Address: The Barn Goviley Major Farm Tregony Cornwall TR2 5TT
Proposal: Conversion and linking of two redundant rural barns to form a single dwellinghouse
Case Officer: Martin Woodley
[Click for further information](#)

Commenter Type: Parish/Town Council
Stance: Customer objects to the Planning Application
Reasons for comment:
- Residential Amenity
- Traffic or Highways
Comments: Cuby Parish Meeting has substantial concerns with this application. It is light on detail on some aspects and silent on others. There are a number of questions and concerns that need to be resolved before we could support the

PROPOSED SOUTH ELEVATION 1:100

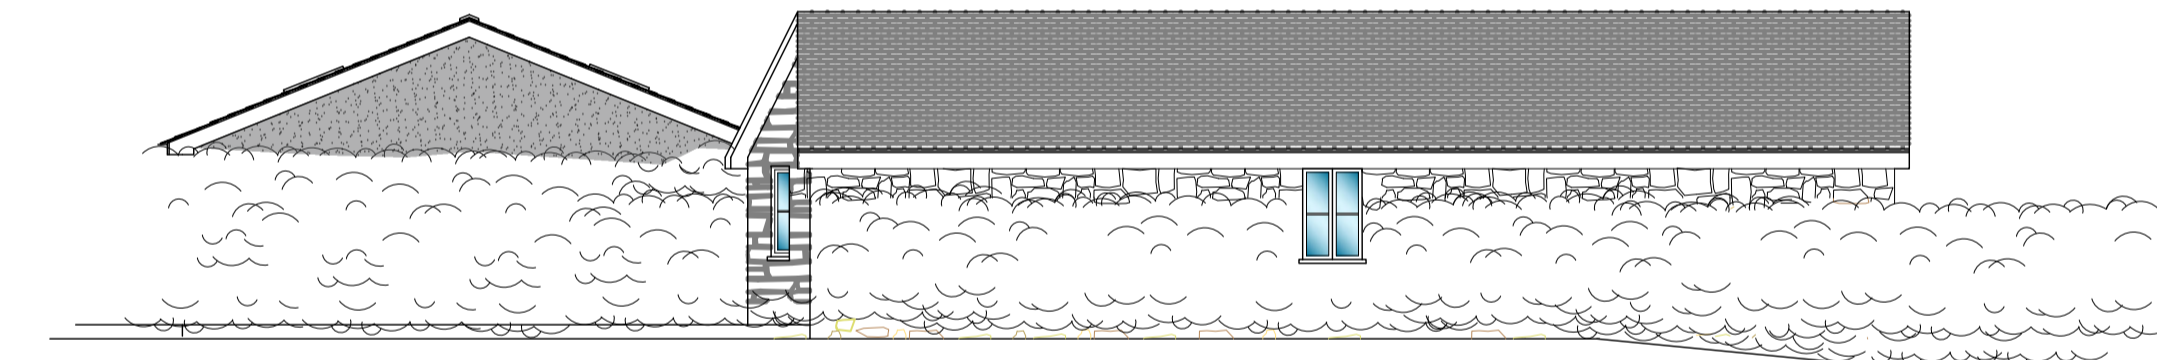
While existing stone work will be retained on the derelict building, the proposal is to use rendered block work elsewhere. We believe that, should the Planning Officer be minded to grant consent, then a condition should be imposed such that the external South facing wall of the kitchen/lounge should reflect lime pointed stonework to match the stonework in other local buildings (The Granary, Goviley Major Farmhouse, The Old Mill, Cart Barn, The Old Parlour etc.) although it has to be observed that the applicant's treatment of the stone work for The Barn is not in keeping contrary to Condition 7 of the consent for that development.

PROPOSED SITE PLAN 1:500

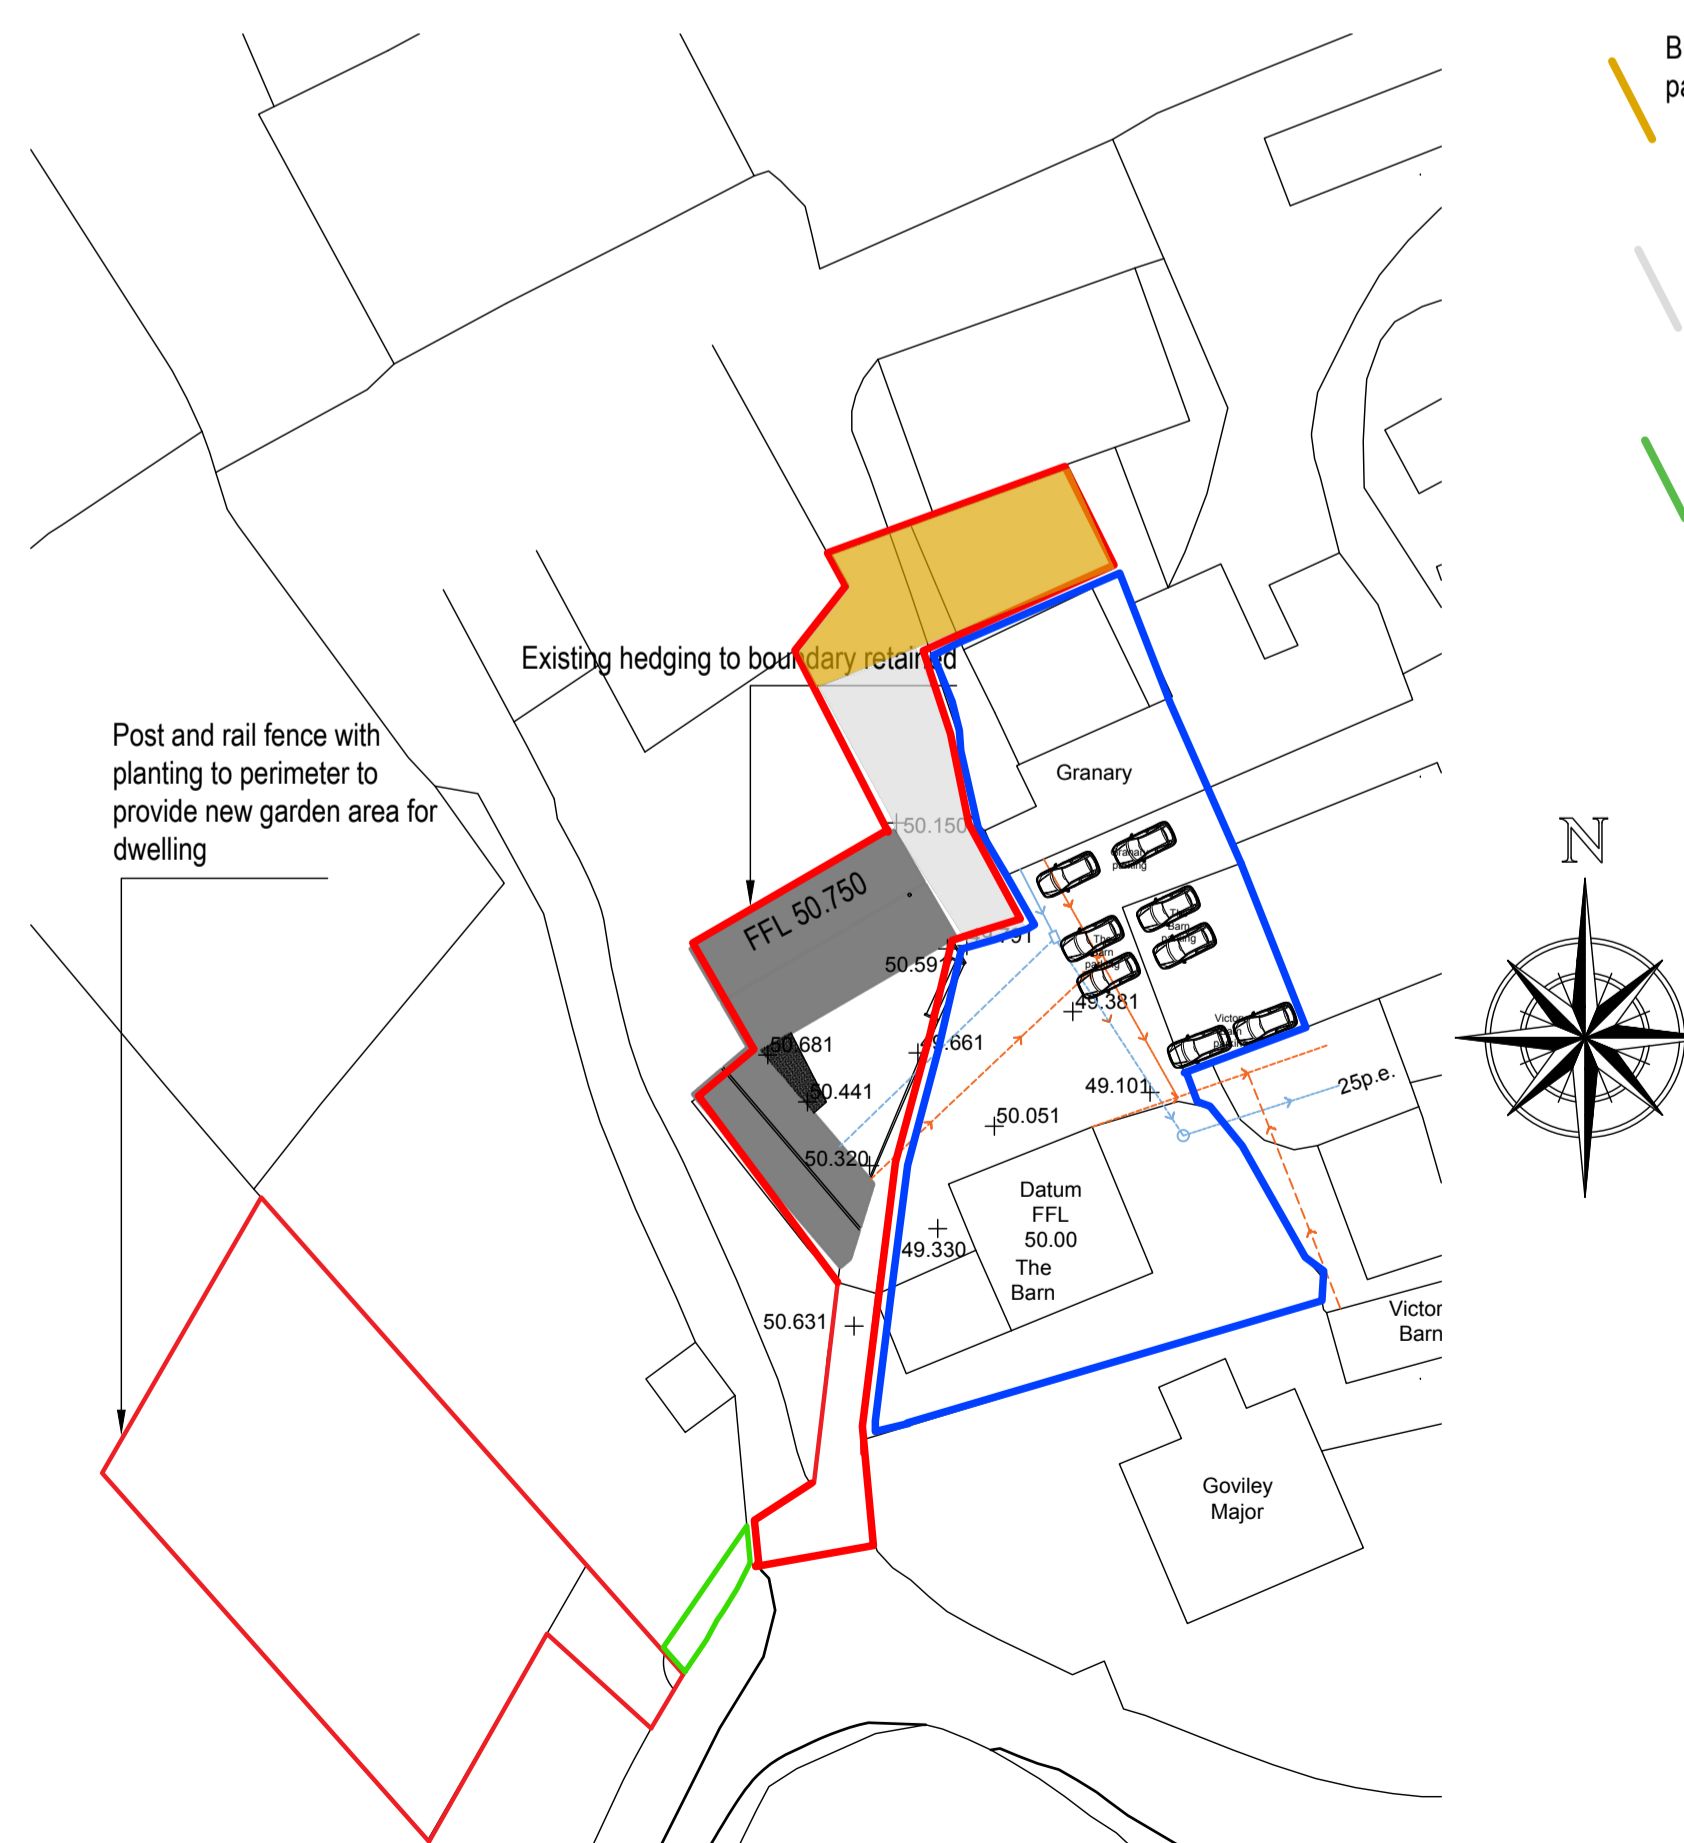
The position regarding access and parking is unclear. There is a single access for a number of residences to which this development would be added. The proposed development includes provision for access and parking for yet a further 2 vehicles. However, what the existing provision for access and parking for the immediate local area is unclear; The Granary (Unit 2 as consented to under PA06/2330/05/R), The Barn and Victory Barn (consented to under PA06/0181/08/R) all share common access from the highway and none have any designated parking. As already mentioned, the proposed development removes the provision for 2 parking spaces for The Granary but which has not (yet) been implemented. The situation is further complicated by the fact that The Granary has since been configured as 2 single bedroom rental properties with, currently, up to 4 vehicles associated with the tenants. We are unsighted as to any permissions or consents for this conversion; we note, however, that the Granary has been assessed as Band A for Council Tax which implies that it has been assessed as a single bedroom property rather than the 3 bedroom property as developed in accordance with PA06/2330/05/R. What is locally known as The Upper Granary or Mortain, does not appear to have been registered for Council Tax. Consequently it is unclear as to what has, or has not, been approved by the Council and, therefore, what the Council accepts as the current residential status of The Granary and, so, what the provision of vehicle access and parking should be (for 2,3 or 4 vehicles?). The plans for the

consented development for the Barn and Victory Barn included provision for 2 parking spaces for each (total of 4 spaces) but these were never implemented. While the Barn also has tenants, we note that Victory Barn is currently unoccupied and, indeed, has been so for some time. The status of Victory Barn is unclear; it was subject to a S106 planning obligation to be configured as a low cost local housing needs dwelling. It was developed and occupied for a short period of time (although it was unclear whether this was under the terms of the S106 agreement) and it may well be that the Council has since decided not to enforce the S106 agreement (and, indeed, that fact that it not registered for Council Tax may be consistent with such a decision) but, if that is indeed the case, then the residential status of Victory Barn needs to be clarified and, accordingly, whether it needs to be considered as part of the overall access and parking provisions. Access and parking for existing residents and properties may therefore be for 8 vehicles for which the applicant has failed to date to make any of the provisions as planned for in existing consented to developments. We believe that this development is likely to result in access difficulties and unsustainable parking provision for the existing local rental properties (but which are all owned by the applicant); this consideration should include the ability for delivery vehicles, which can include oil tankers and similar large vehicles to safely manoeuvre. We strongly recommend that the Council establishes a clear position on the residential status of all the properties served by the single access and invites the applicant to submit plans that provide a safe access and parking for all vehicles that use and service the local properties.

It should be noted that the area for development includes land to which the applicant does not have title; indeed it includes part of the Council maintained highway! This is relevant as the applicant has stated, as part of the application, that he owns all of the land stated in the application; this is patently incorrect.

The application shows an element of the Registered Woodland as part of the development. The application is silent on exactly what the intent is for this land. The implication is that it would be fenced off and remain as Registered Woodland. However, as the only green space linked to the residential part of the development there is a suspicion that in time this area may be developed, possibly leading to removal of trees and conversion to horticultural use. The applicant's intent for this space should be clarified and, if necessary, change of use applied for accordingly. We also note that access to this area is not indicated; currently this is from across land owned by Goviley Farm for which no easement formally exists to do so. The applicant should also be invited to clarify his intent for this access.
